Review Response

Project Name: Cui Pier Extension

Response To: Planning Comments

This letter is in response to the corrections SHL23-030 & SEP23-012. Below are our responses to the questions/comments from 09/26/2023.

PIER DETAILS - EXISTING/PROPOSED PLAN VIEW

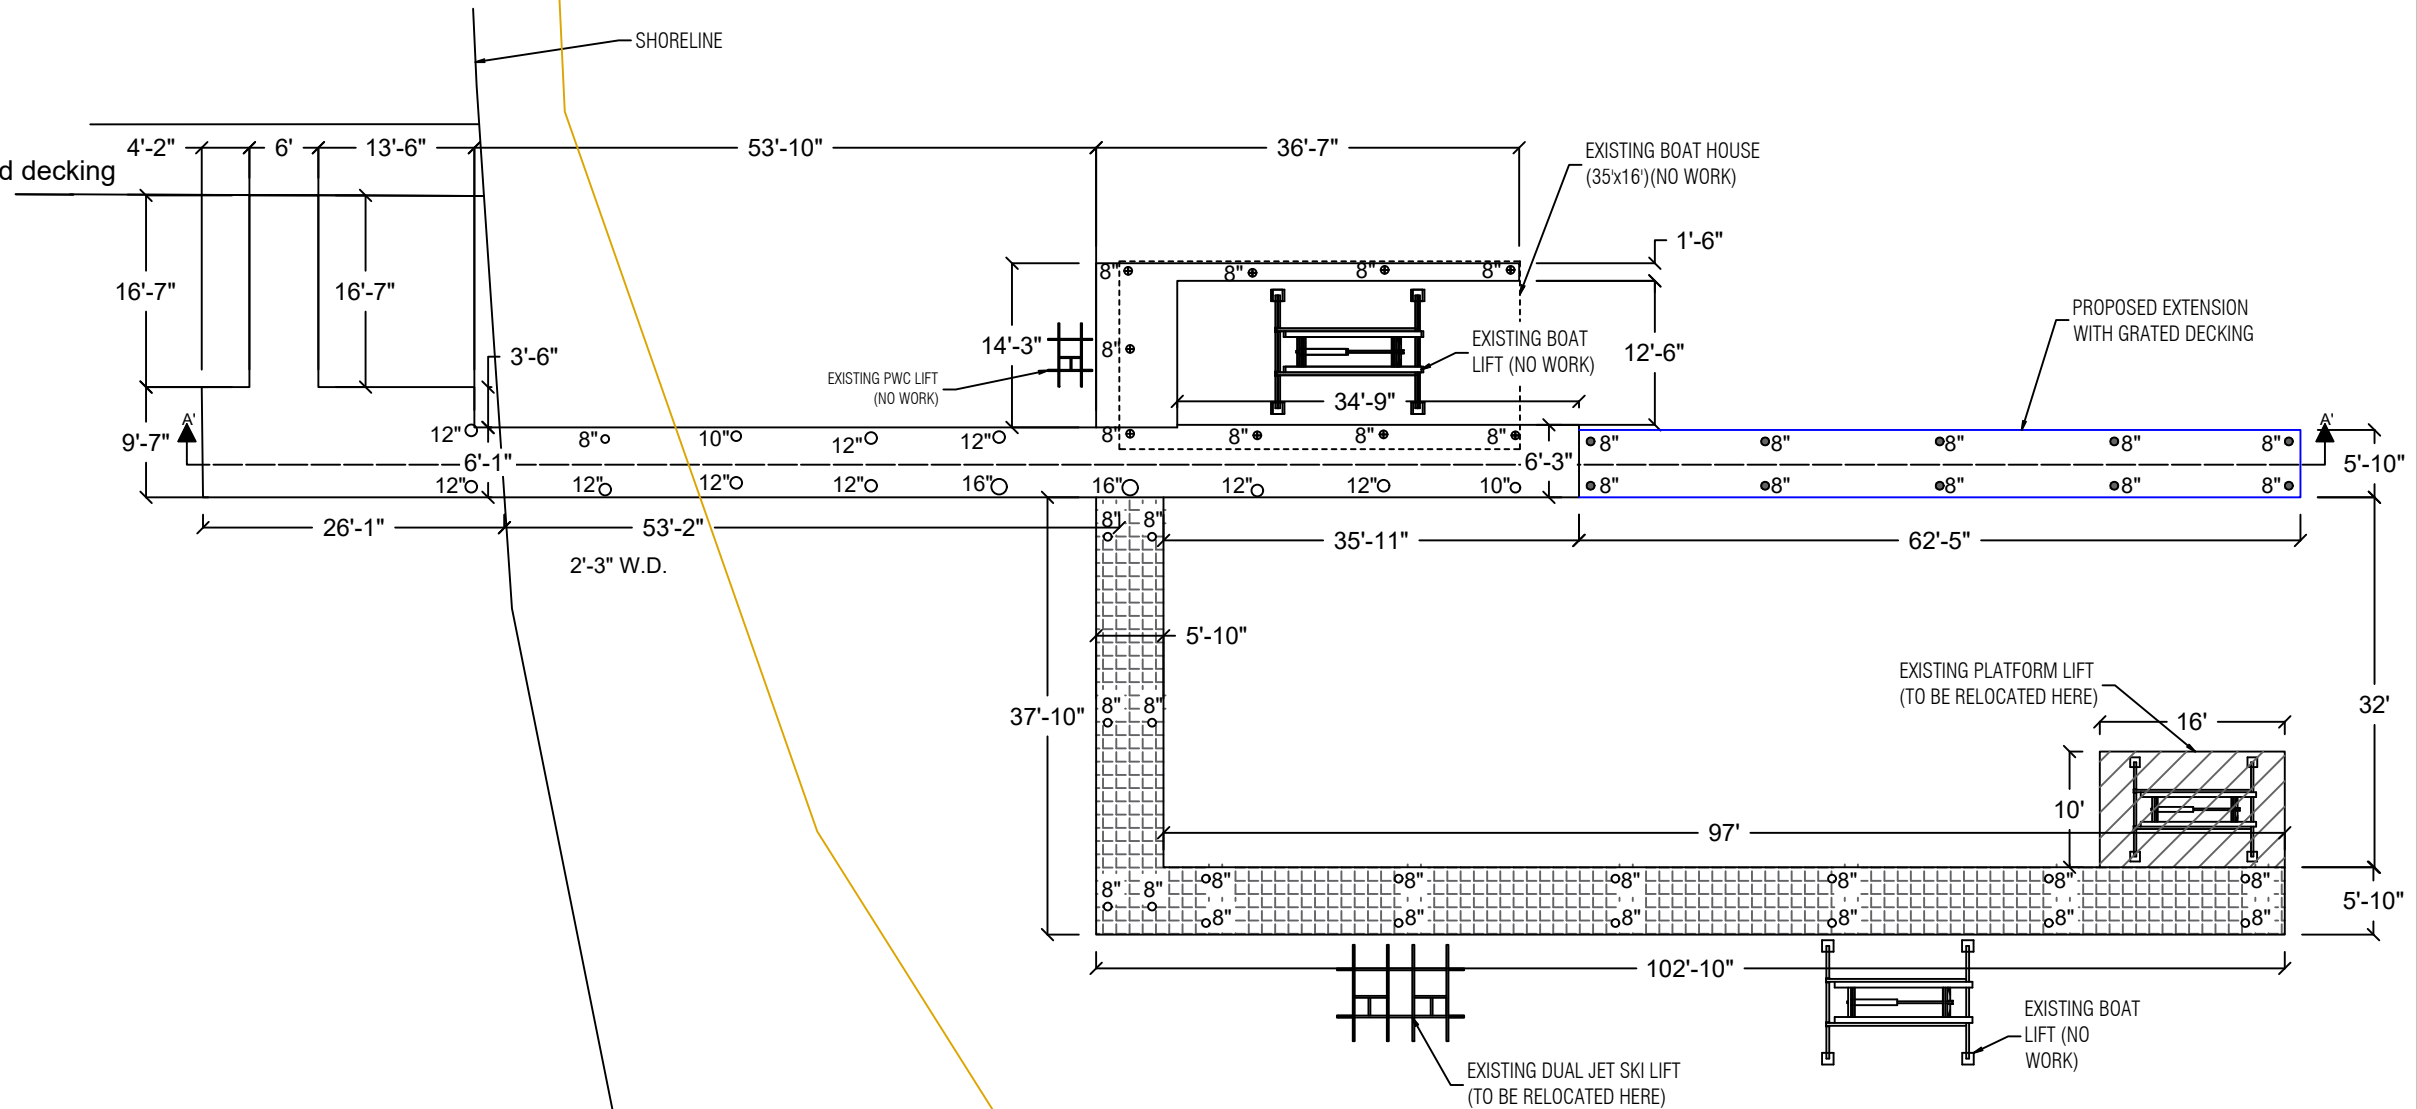
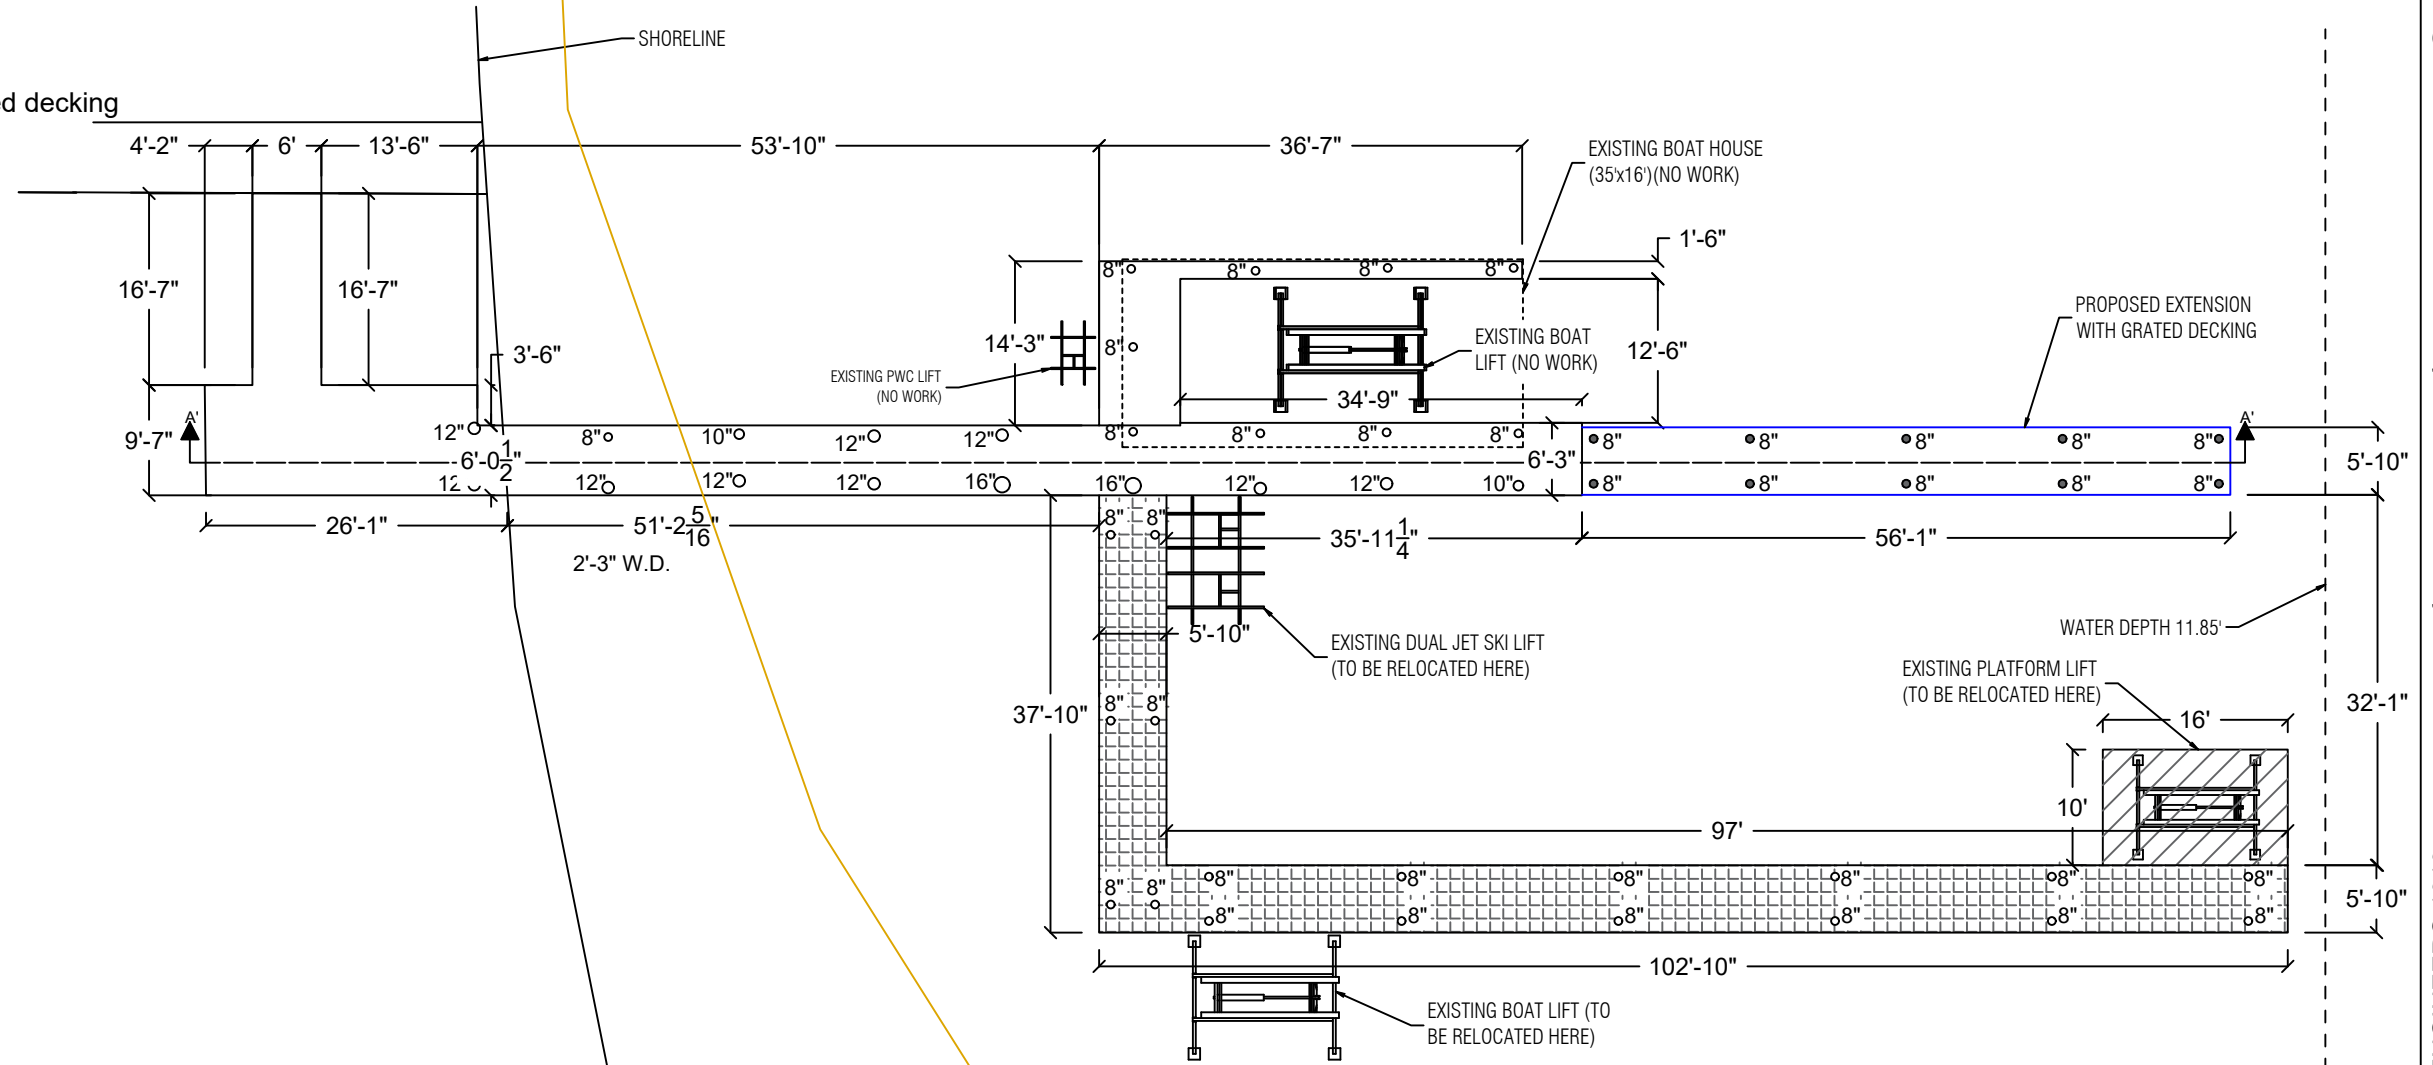
1. "Length of the Proposed 8636 Dock"
 - a. Proposed dock will not be longer than the existing 8630 dock, this was an error during drafting, we noted the extensions needed to be the same length, we are reducing the extension to meet code compliance.

MITIGATION PLAN

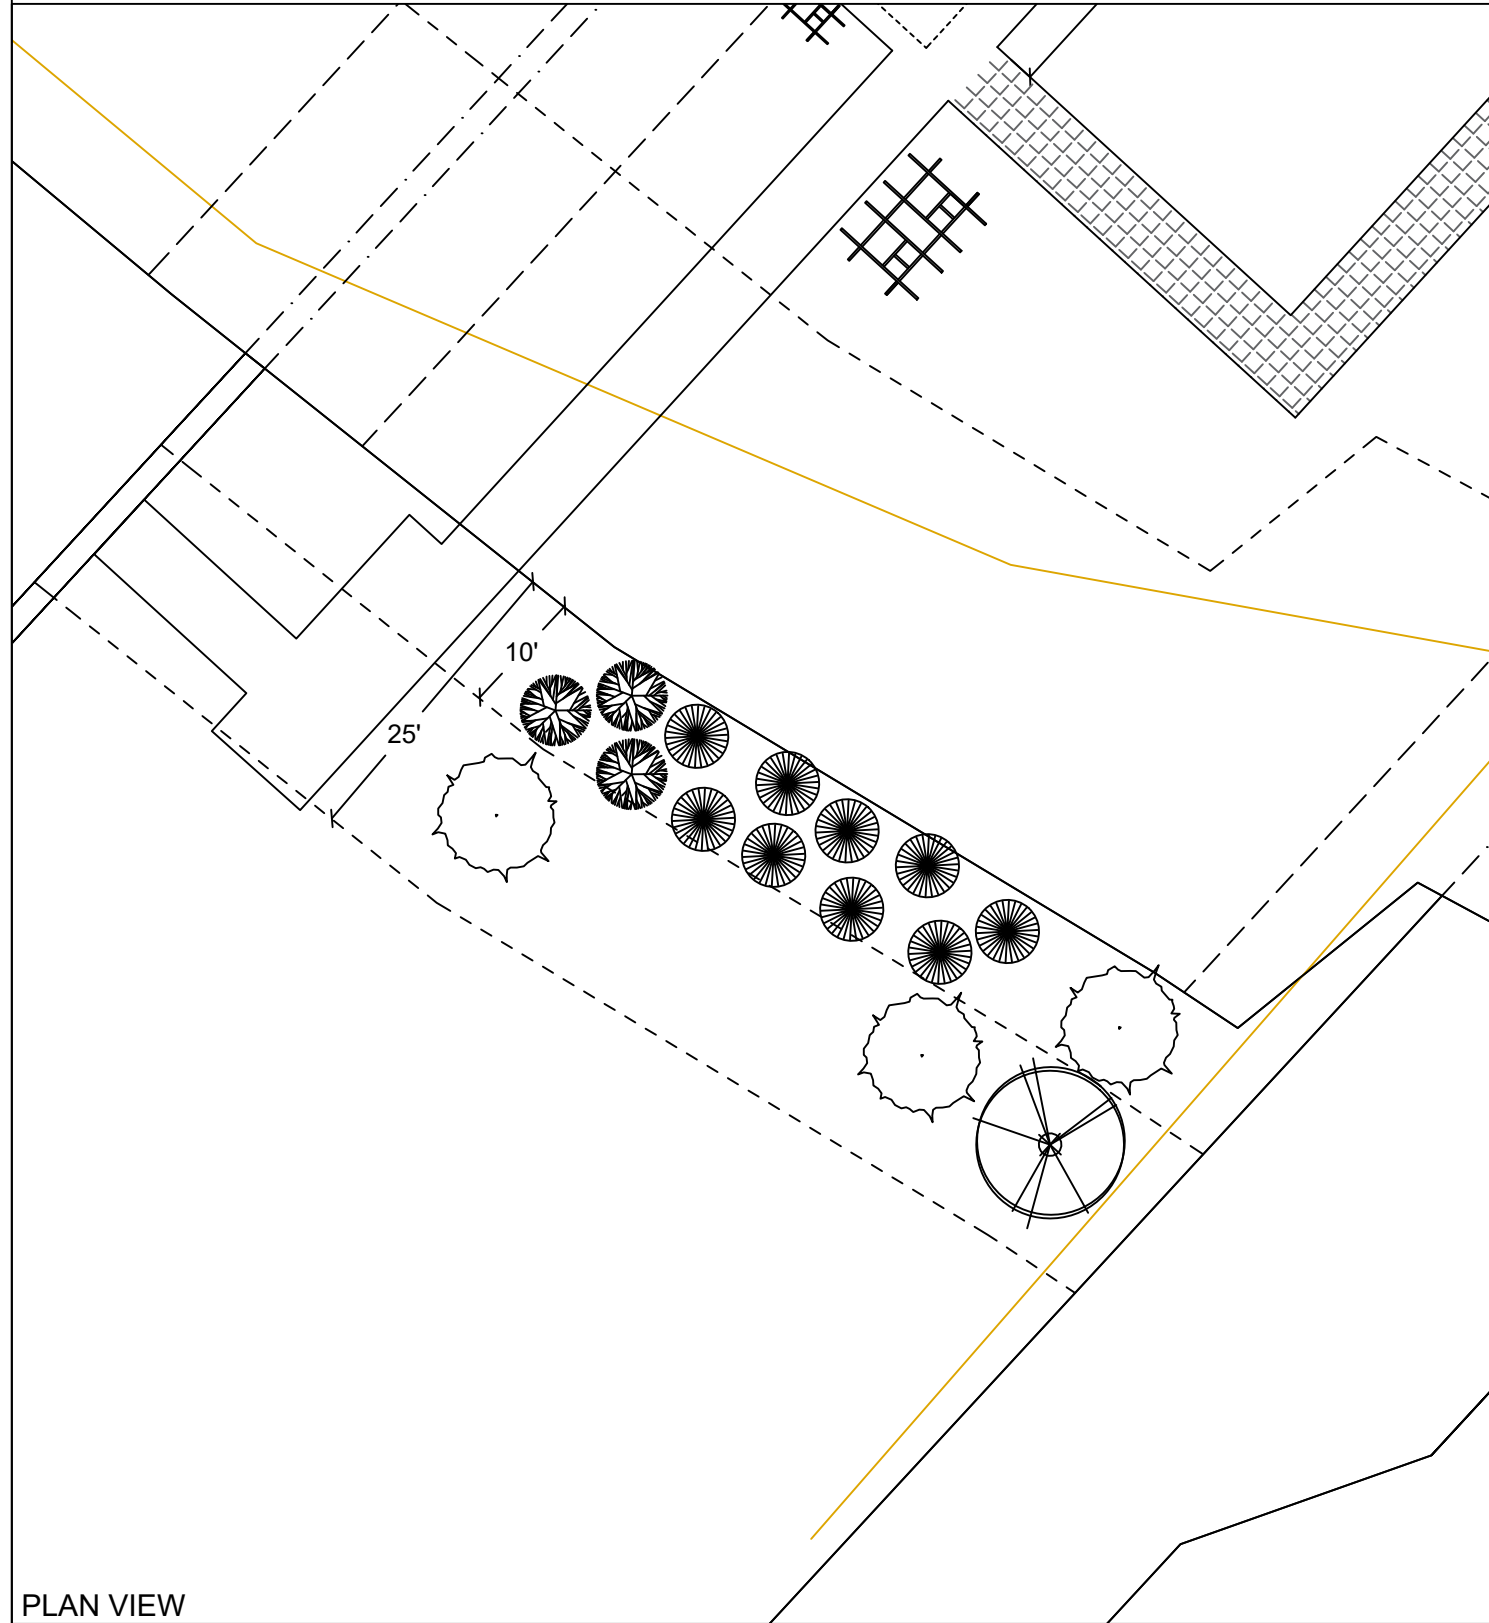
- c. No additional permit requirements due to legal nonconforming status of the existing boat house.
 3. Net Loss Report
 - a. Landscape plan has been updated.
